Application no: 23/01586/REM

Location: Proposed Himley Village North West Bicester, Middleton Stoney Road, Bicester

Lead Local Flood Authority

TITLE
DRAINAGE STRATEGY - PHASE 2A

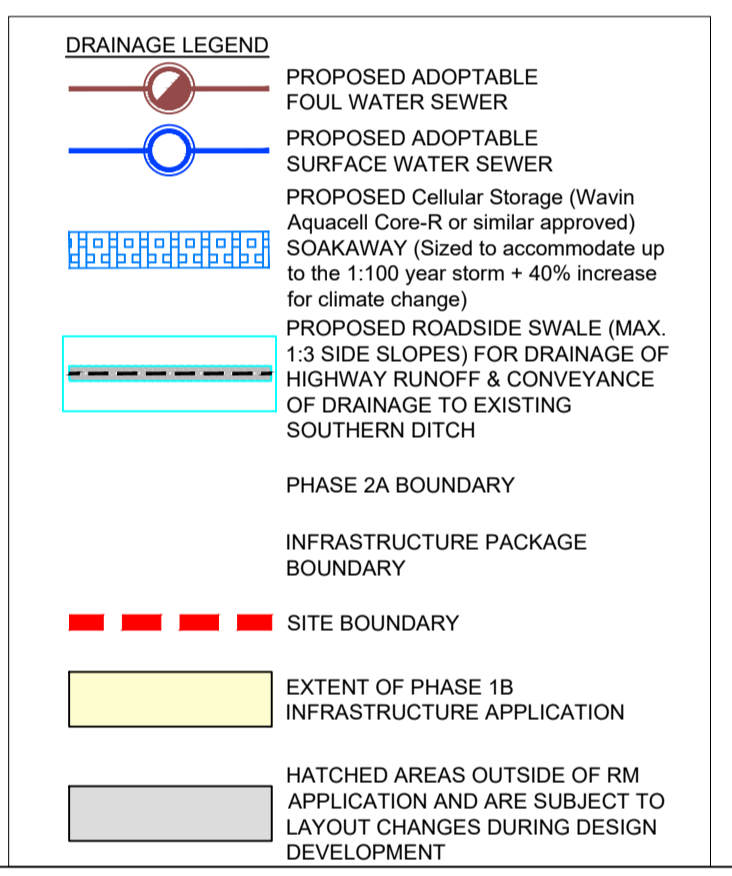
- Revised hydraulic calculations are required to accompany the updated drainage layout.

Phase 2A Drainage Strategy Sheet 1 of 2 -27141-HYD-PH2A-XX-DR-C-2310-P01 has now been updated to revision P03. The hydraulic calculations should be updated to account for the changes in the drainage layout, ensuring that the drainage system remains suitable for the proposed development.
